St Francis Catholic College, 130-160 Jardine Drive, Edmondson Park (SSD 8832)
Notice of Exhibition

TAB A – Comments on SSD 8989

Figure 11: Existing parking layout (67 car spaces) (DA-456/2016) (Sources: JDH Architects & Bitzios)

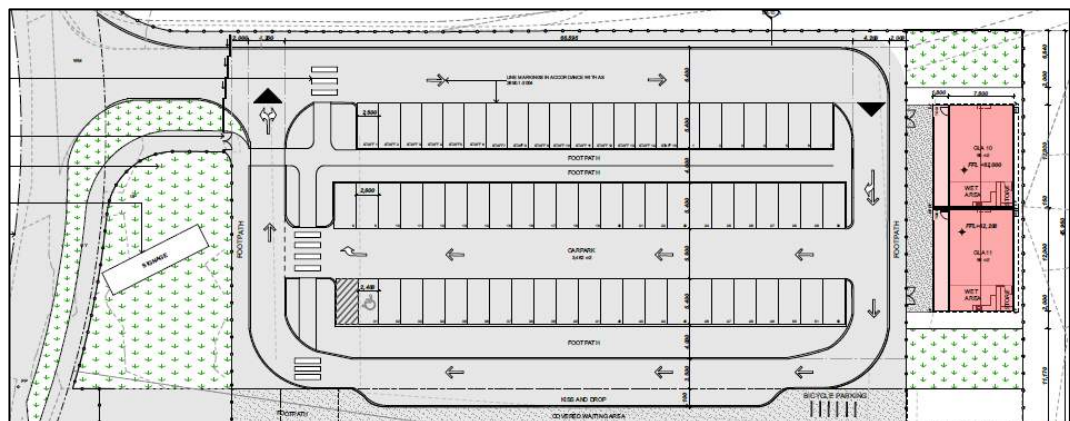
Figure 4.1 of the Traffic Impact Assessment Report (prepared by Bitzios, June 2018) indicates that the egress onto Jardine Drive is currently and will remain left-out only. Aerial imagery, taken on 17 July 2018, of this access is shown in Figure 1 below. It is unclear whether the existing design can effectively restrict egress movements to left-out only.

The Applicant should consider modifying the design of the existing vehicle access on Jardine Drive to ensure that egress movements are restricted to left-out only as intended. This could be undertaken as part of Stage 2 works.
